Ann Machado - 135 Congress St. - Permit #2013-02268 - Legalization of nonconforming dwelling unit.

From: Ann Machado
To: William Simpson
Date: 10/9/2013 3:03 PM
Subject: 135 Congress St. - Permit #2013-02268 - Legalization of nonconforming dwelling unit.

SHEET TITLE:
SECOND FLOOR PLAN

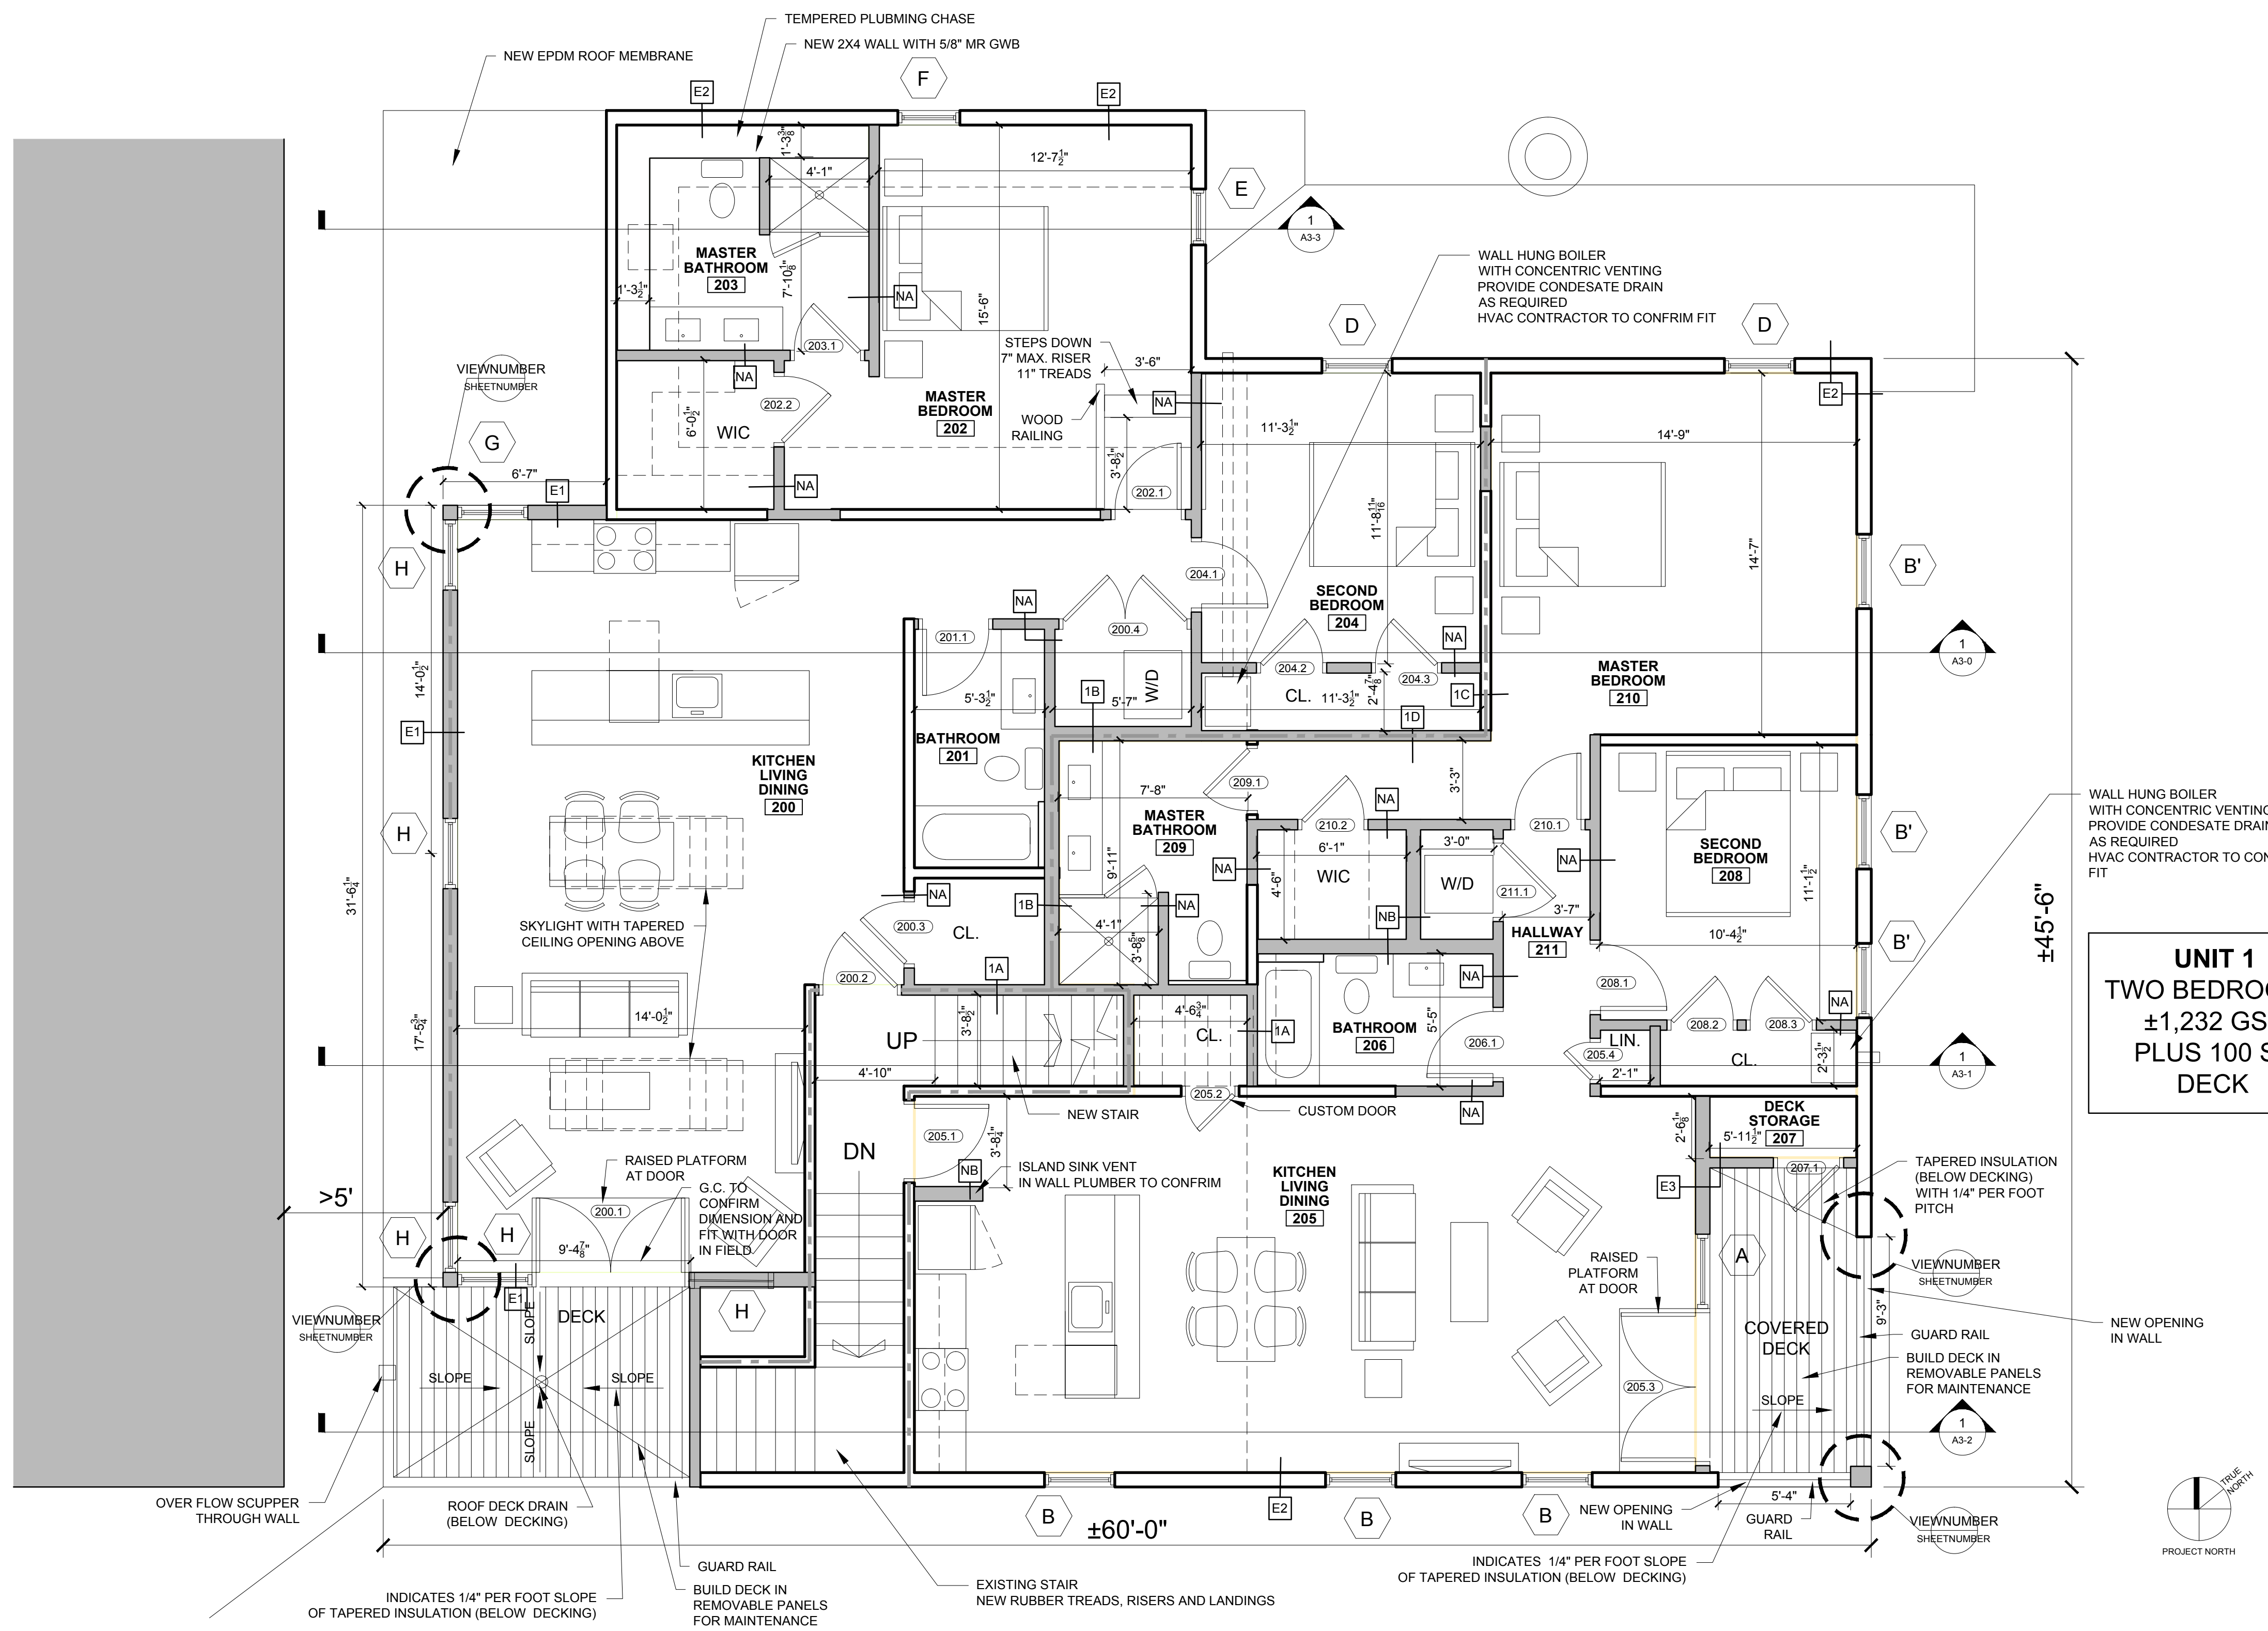
The floor plans that were provided with the permit are for the proposed renovations/alterations to the second and third floor under permit #2013-01923. They do not show the existing conditions. Part of the process to be able to legalize a nonconforming dwelling unit is that the building has to meet the Housing Code and the Life Safety Code. I don't know if the building in its present state can do that. It may depend on the work proposed for the second & third floor under permit #2013-01923 be completed and then the legalization could be approved.
